To: Harnett County Building Inspections Department

Job: Weaver Devlp. - Lot 5 Barbecue Church Rd. / Harnett Co.

Concern: Floor Truss F2 Set Backwards

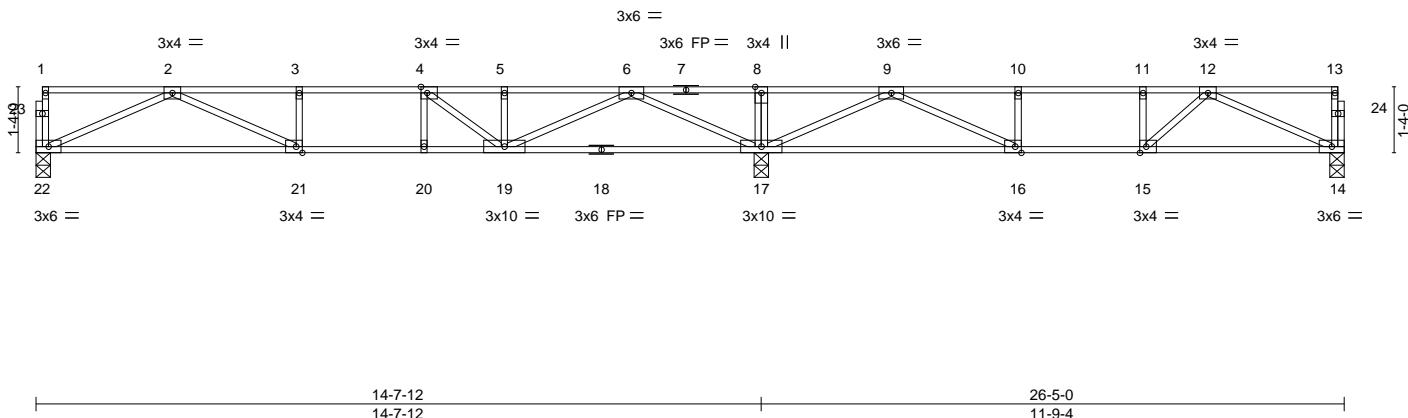
The double vertical web on the left side of the chase located at 4' 3" from the left end of the "F2" truss is only placed there in order to decrease the chase opening. Without the extra vertical web the chase would have a 2' 7" opening which surpasses the maximum chase opening of 2' 6". There are no additional loads added to the "F2" truss that requires the double vertical web to be there. The "F2" truss is essentially a symmetrical truss and can be turned so that the left end shown on the layout and truss drawing is on either the exterior wall or the stairway wall. Let me know if you need any further information.

No Repair is needed.
